**FLOOD RISK RELATED COMMENTS ON DEADLINE 3
SUBMISSIONS IN RESPECT OF SCOTTISH POWER
RENEWABLES EA1N AND EA2 PROJECT ONSHORE
WORKS NEAR FRISTON**

**For
SASES**

January 2021

Job: SASSEFRA
Report Number: 210110
Version: v.02
Issue Status: Draft
Prepared by: Clive Carpenter
Issue Date: 12th January 2021

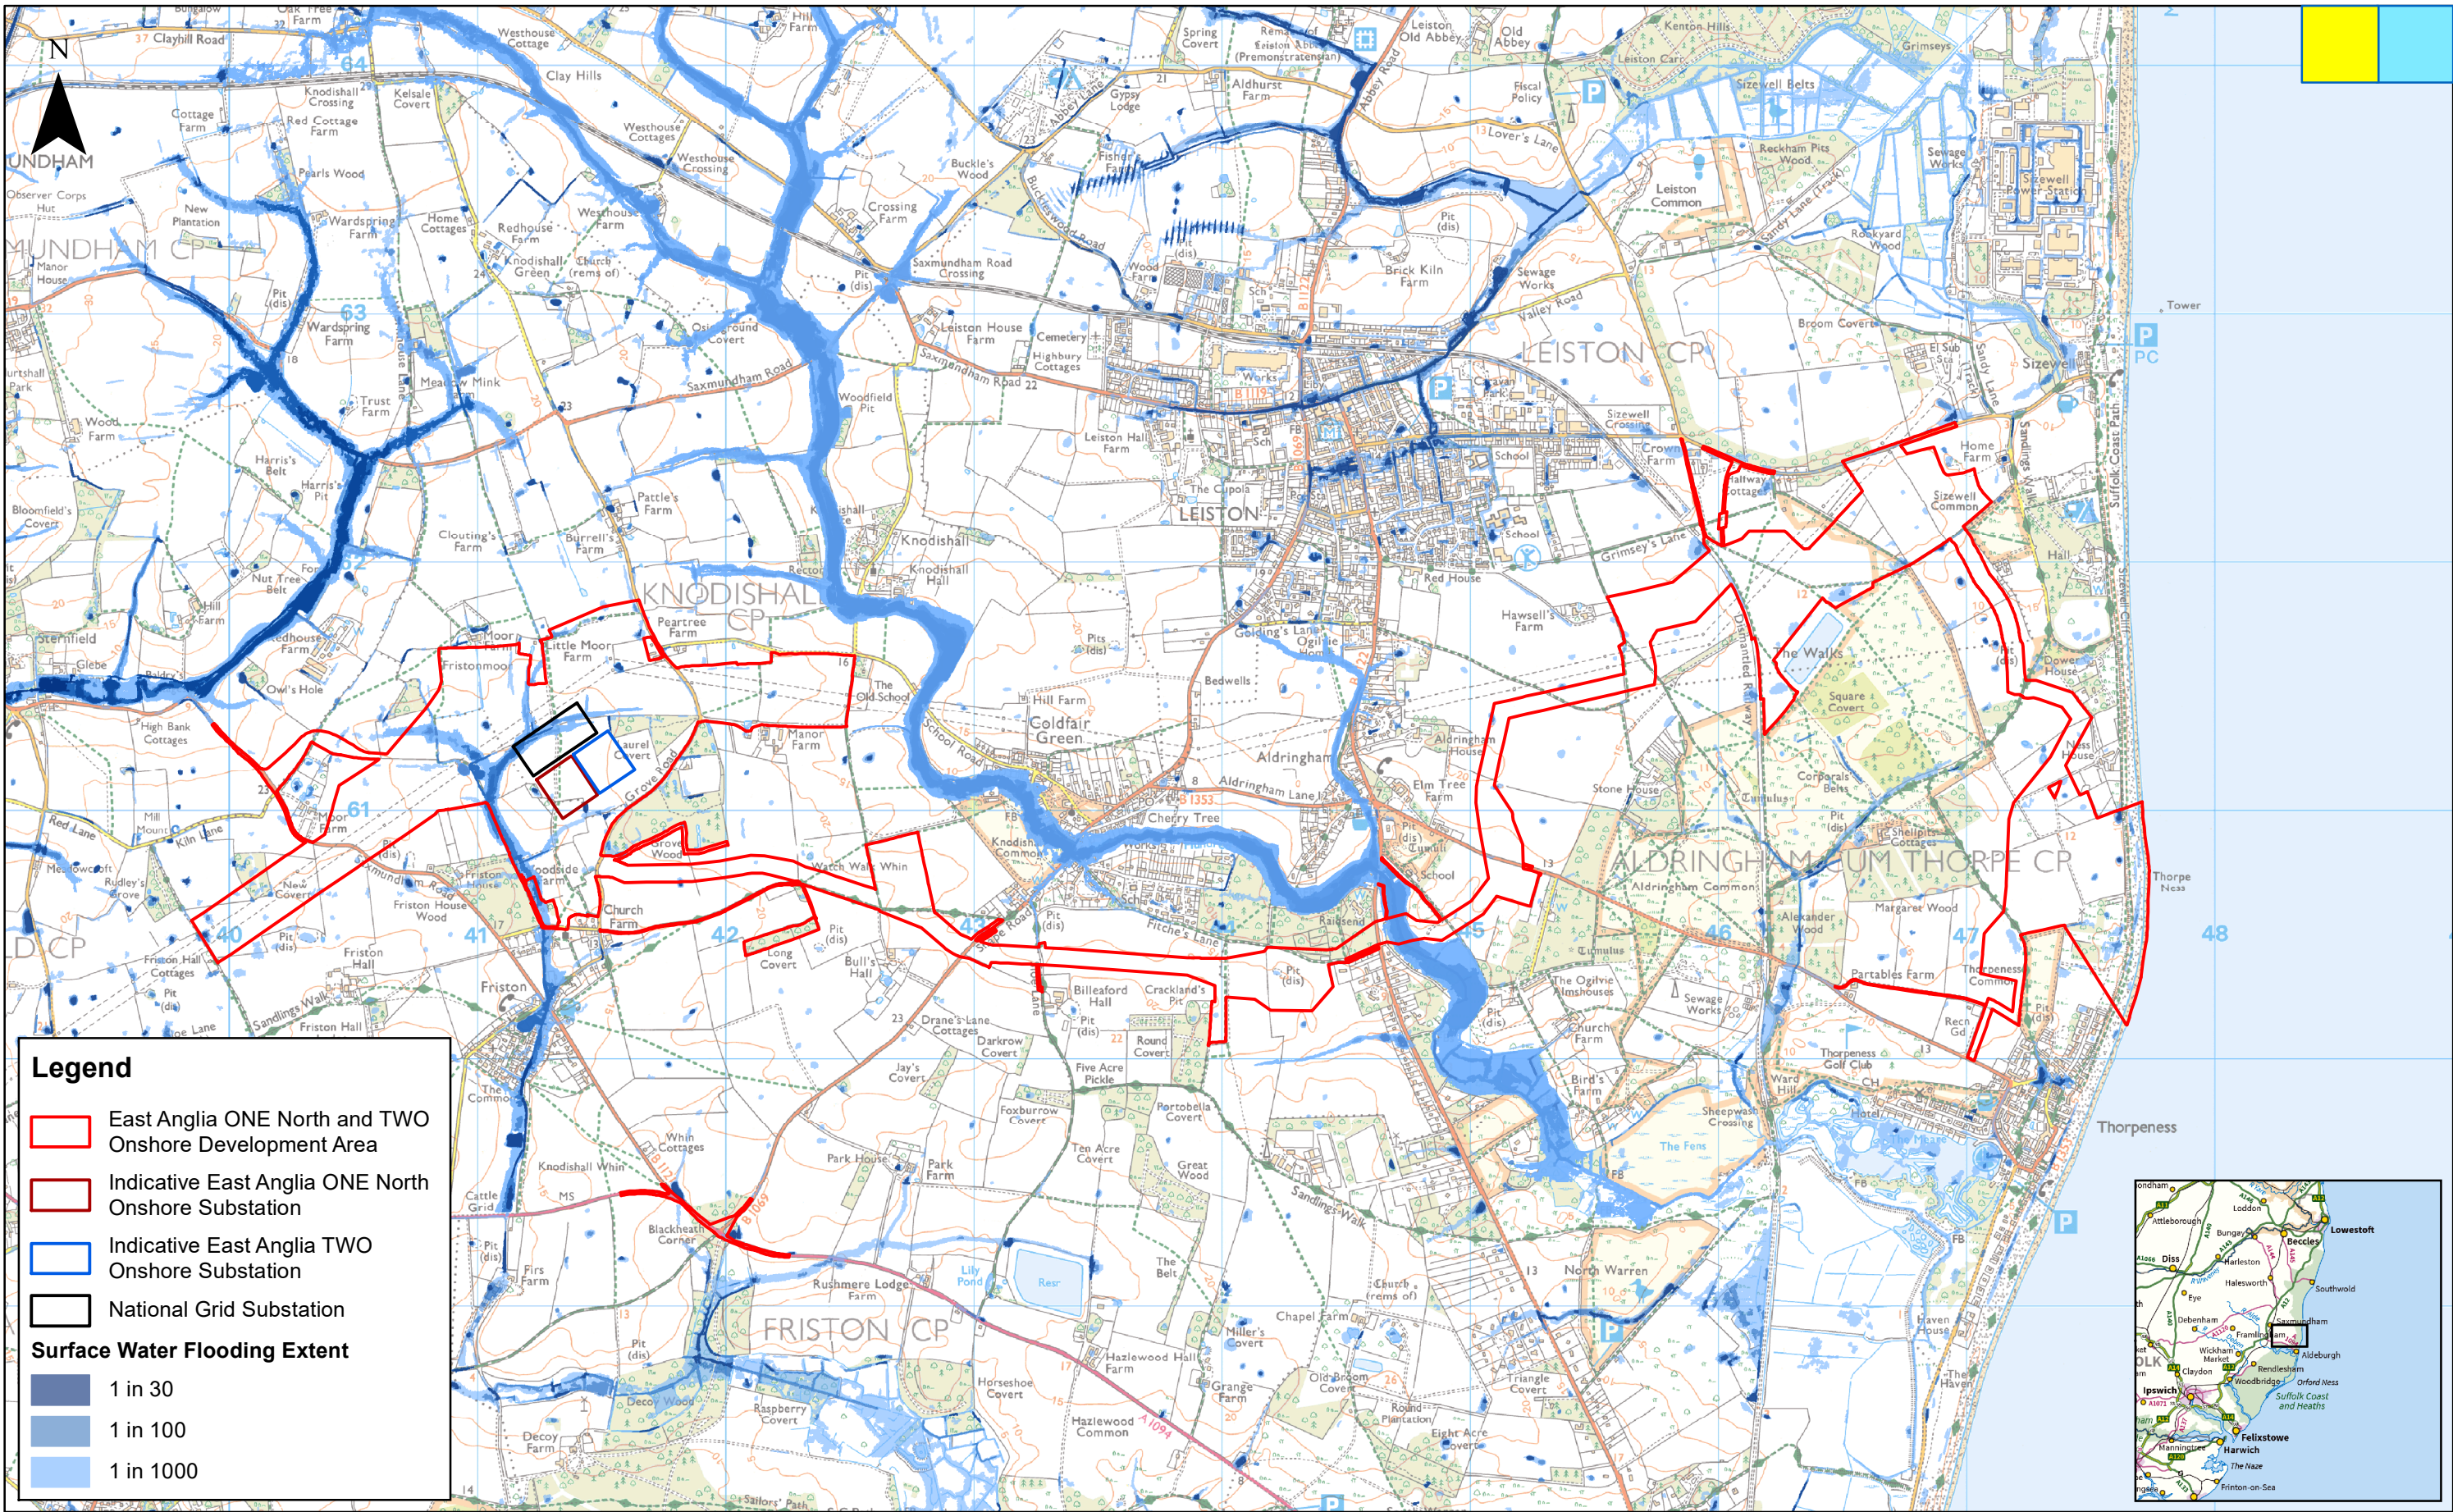
The Applicant has also included a surface water flood risk map, which clearly shows the overland flow routes hydraulically linking the proposed development site to the water courses flowing through Friston Village.
